September 1, 2023

Ryan Harriman, EMPA, AICP  
Planning Manager  
Community Planning & Development  
City of Mercer Island

**Re: File No. SHL 14-031  
Cherberg Dock at 9418 SE 33rd Street  
REVISION TO SHORELINE PERMIT**

PIER DETAILS - EXISTING/PROPOSED

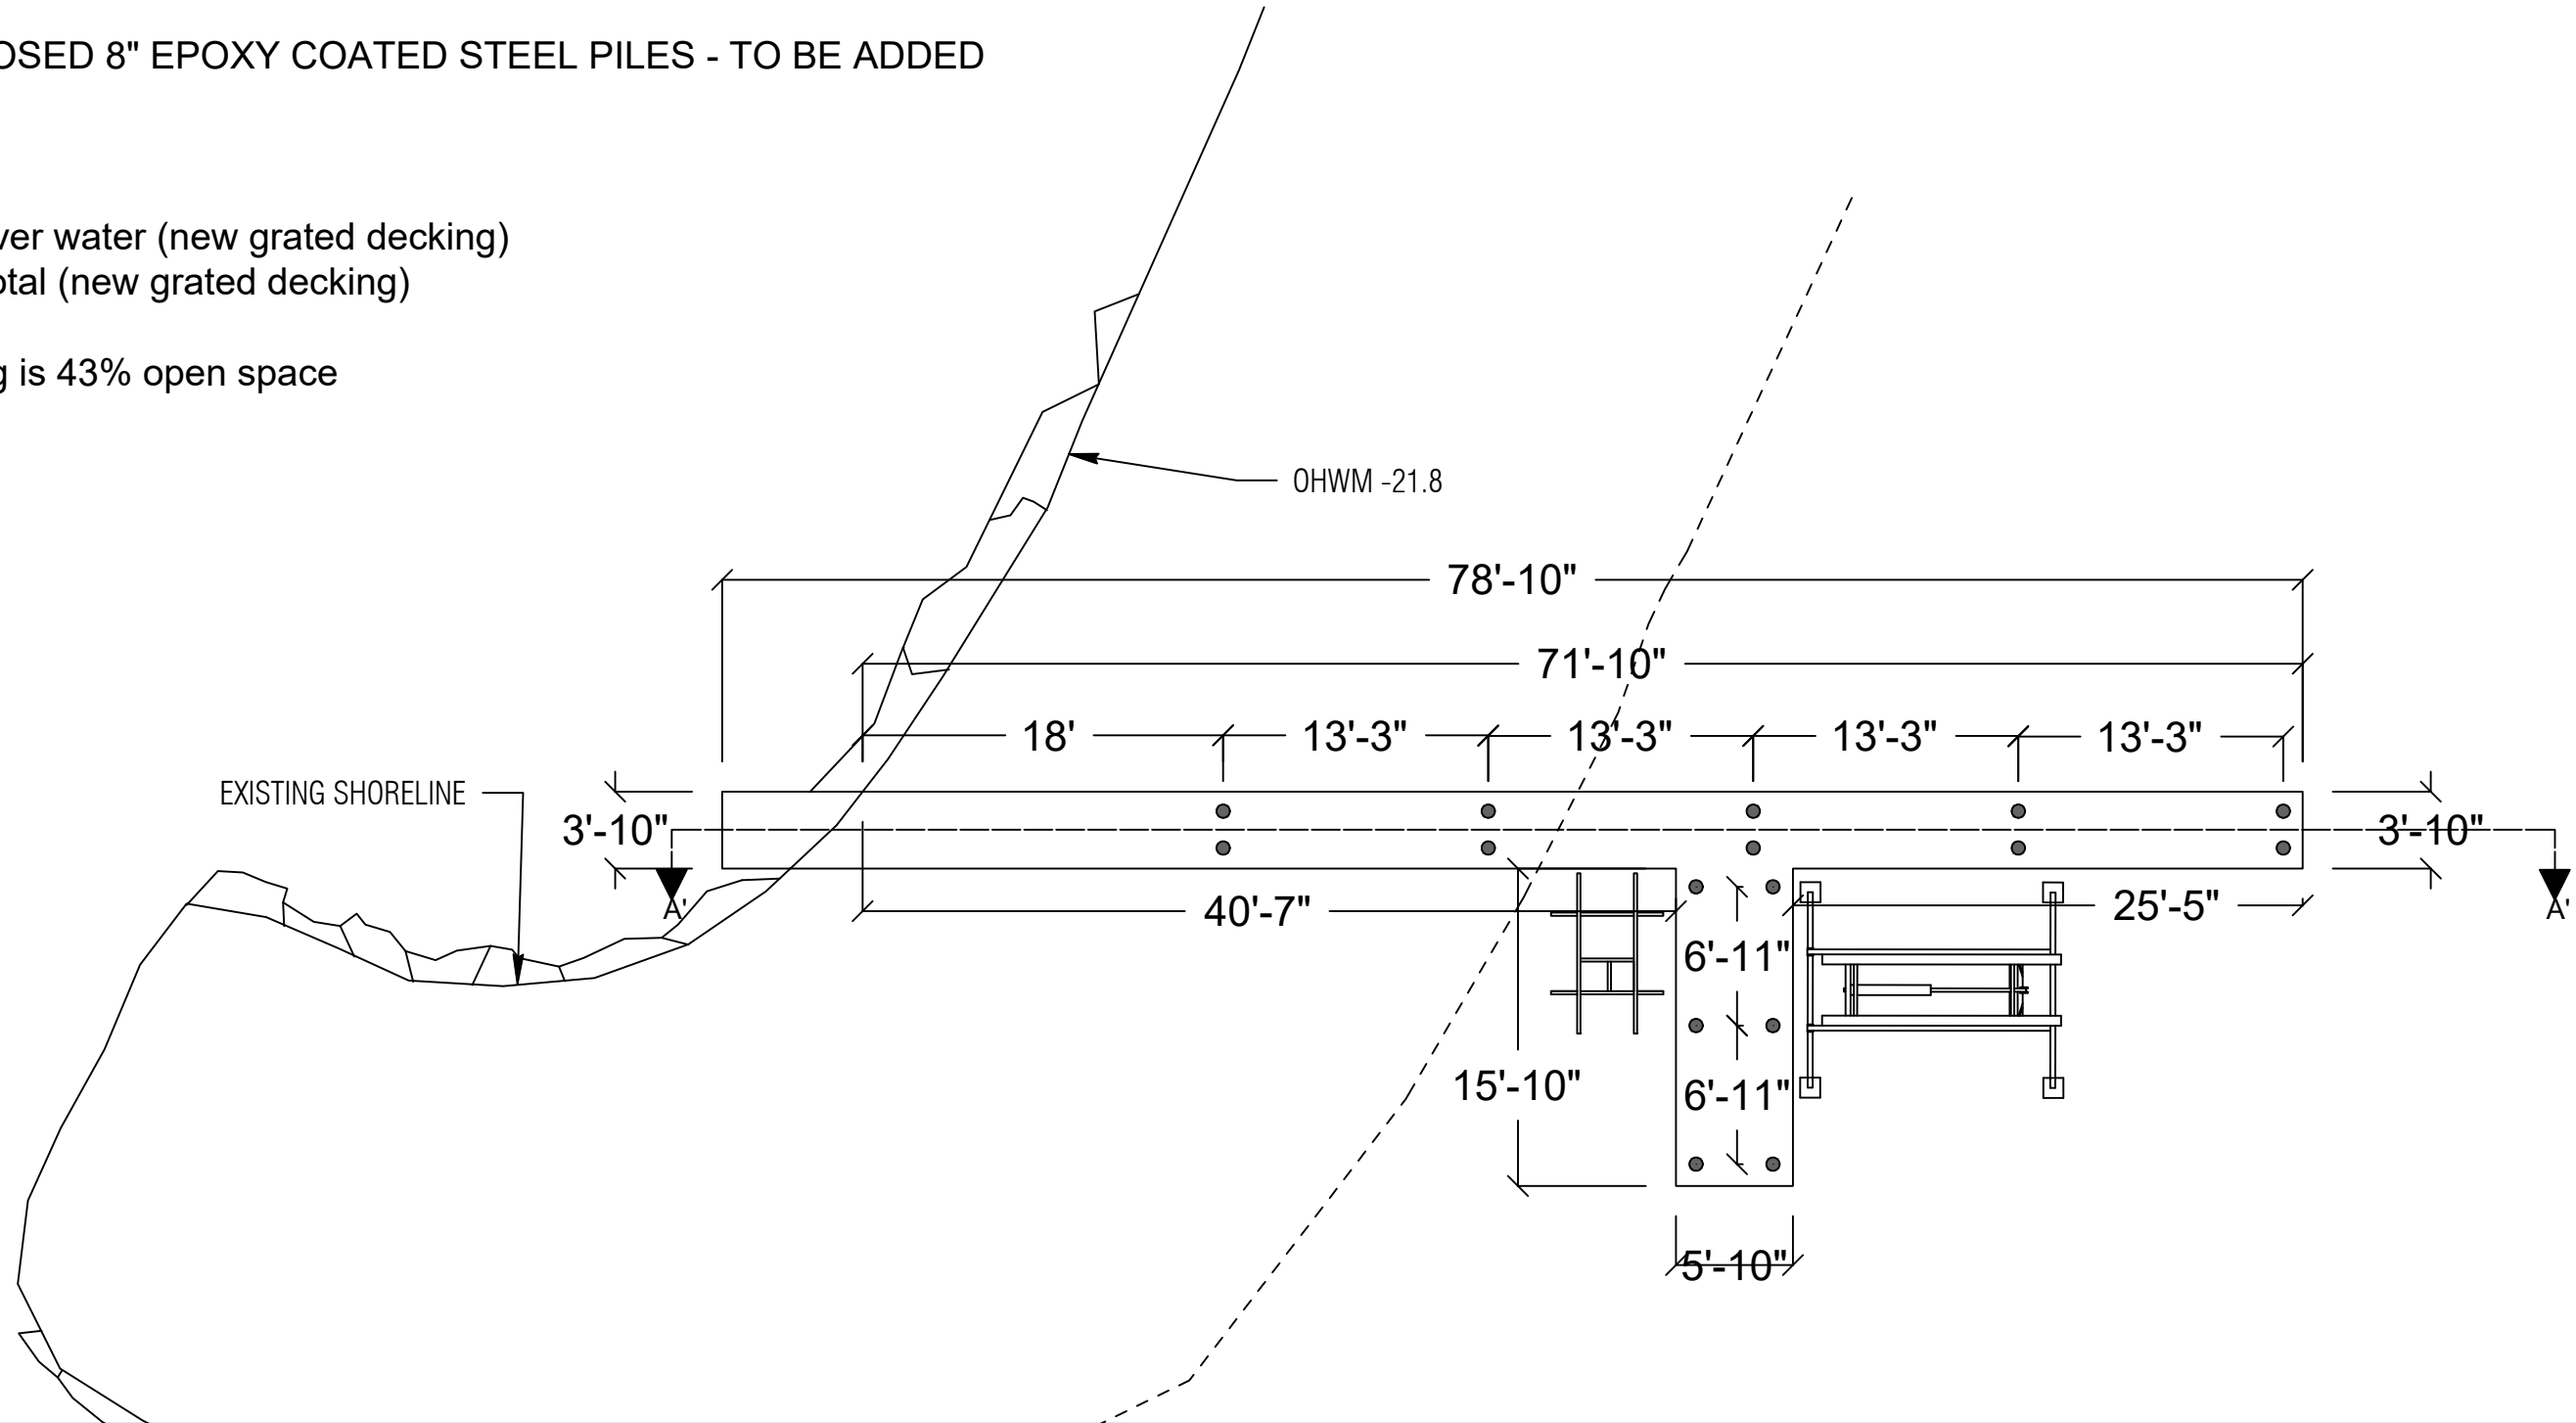
This letter is being submitted on behalf of the applicant James Cherberg and is being submitted by Seaborn for the above issued shoreline permit. In July, a modified plan was submitted to the City that removes the southeasterly finger pier. The Cherbergs are now applying to the City and asking the City to approve this minor modification to the project. Seaborn is submitting a very slightly revised plan set dated 7/27/23. The only change from the plan set submitted earlier is to add notes on the Mitigation Planting Plan identifying all the existing trees that are to remain.
